Application number: 2022/92406	
What is the application for?:	Erection of 10 affordable dwellings, with access from Chapelgate and associated
Address of the site or building:	Land Adj, 67, Chapelgate, Scholes, Holmfirth, HD9 1SX
Postcode:	HD9 3BW

Type of comment: An objection	
Do you wish your comments to be published on the website anonymously?	Yes
Due to the limitations of the submission form, I have divided my comments into 2 parts. Part 1 of a 2 part objection. Let me start by saying that I apologise for the rushed nature of this objection, the window of opportunity to read, digest and cross reference the changes to this application has been incredibly short, given the sheer volume of materials submitted. Size of the site. It has been stated that the quarry site covers an area of approximately 0.37 hectares. This figure is wrong, it has obviously been derived from the figure given on the OS maps, however that figure includes the smaller portion of my field adjoining the site, and the area taken up by the existing garage on the other side. Using this wrong figure has ramifications, for example regarding the tree density amongst other things. Proximity of water catchment. It has

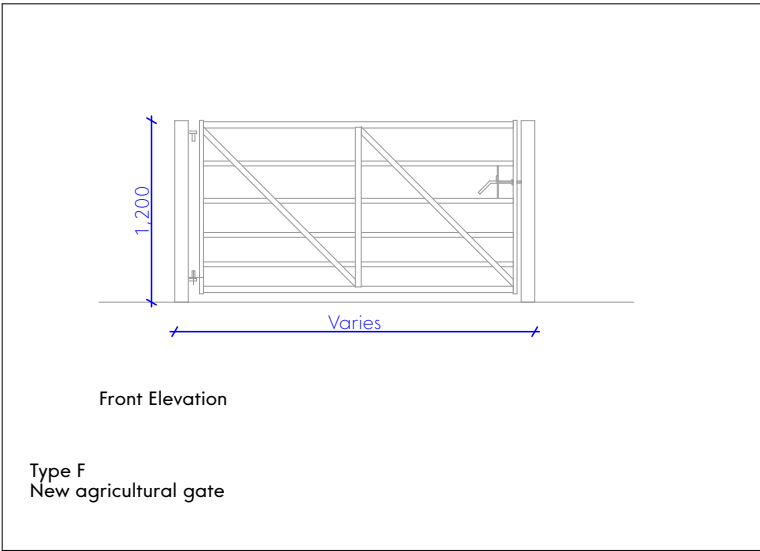
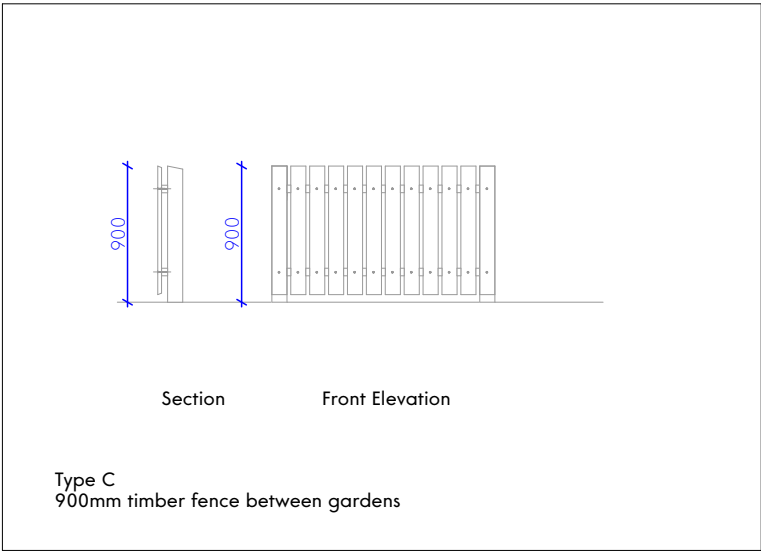
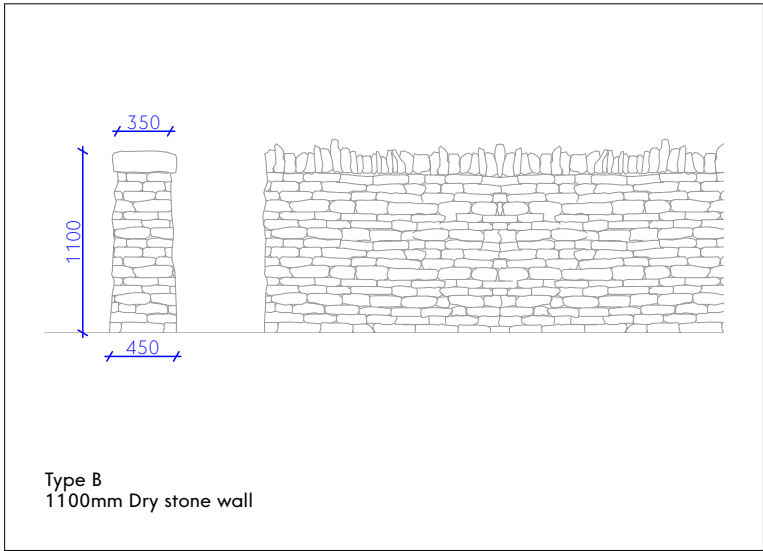
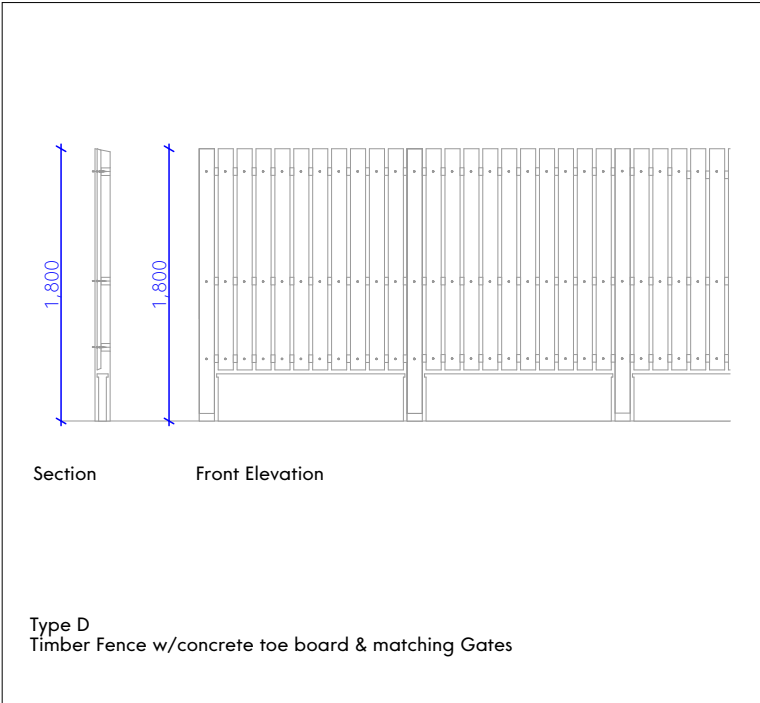
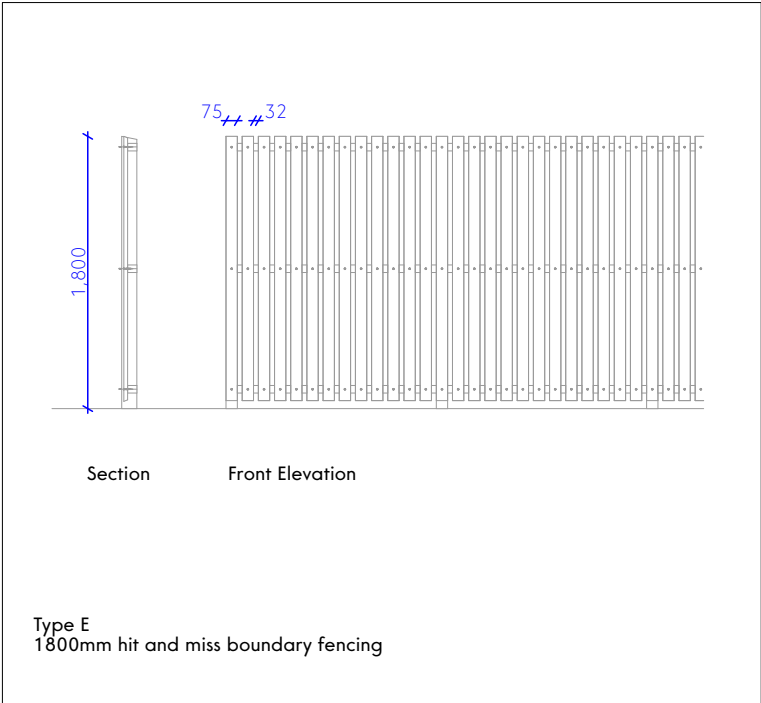
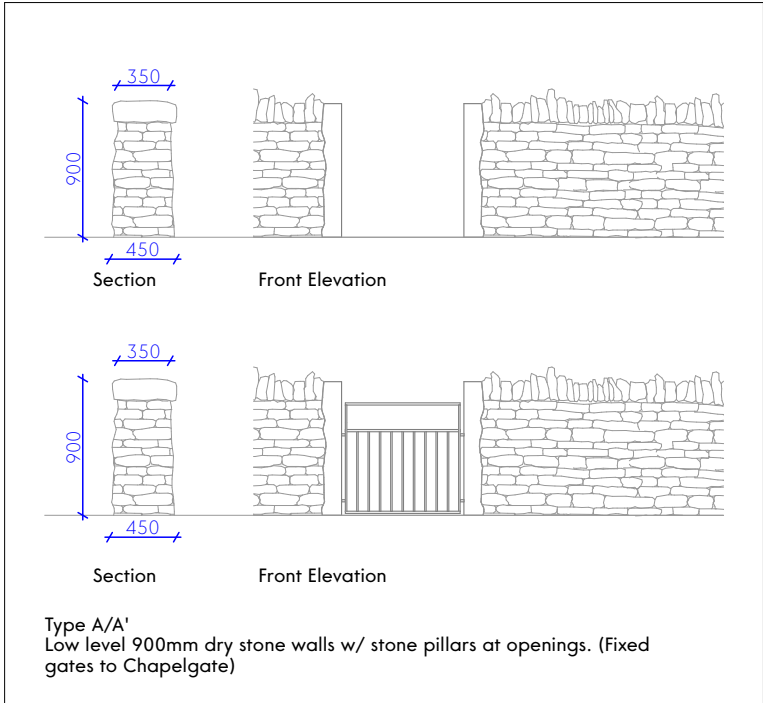
A change that they have made which stands out to me personally, is that instead of having a fence situated on their site, they now propose to carry out works to the existing dry stone wall, well that wall is my property, it is on my land, not the quarry site, and they do not have permission to interfere in any way with it. This change to the plans is apparently to mitigate concerns raised by Kirklees Council regarding elements which will be "to the detriment of openness". I hardly think that a minor change such as this is going to offset the detriment caused by two socking great housing blocks! I also notice that they propose to plant new specimen trees of species which will grow very large, in the gardens of block B. These appear to be situated very close to my boundary wall, which means that they will inevitably encroach under and over my land. Whilst I am generally in favour of tree planting, consideration needs to be given to allowing sufficient space for them to mature, and how they might impact on neighbouring land owners.
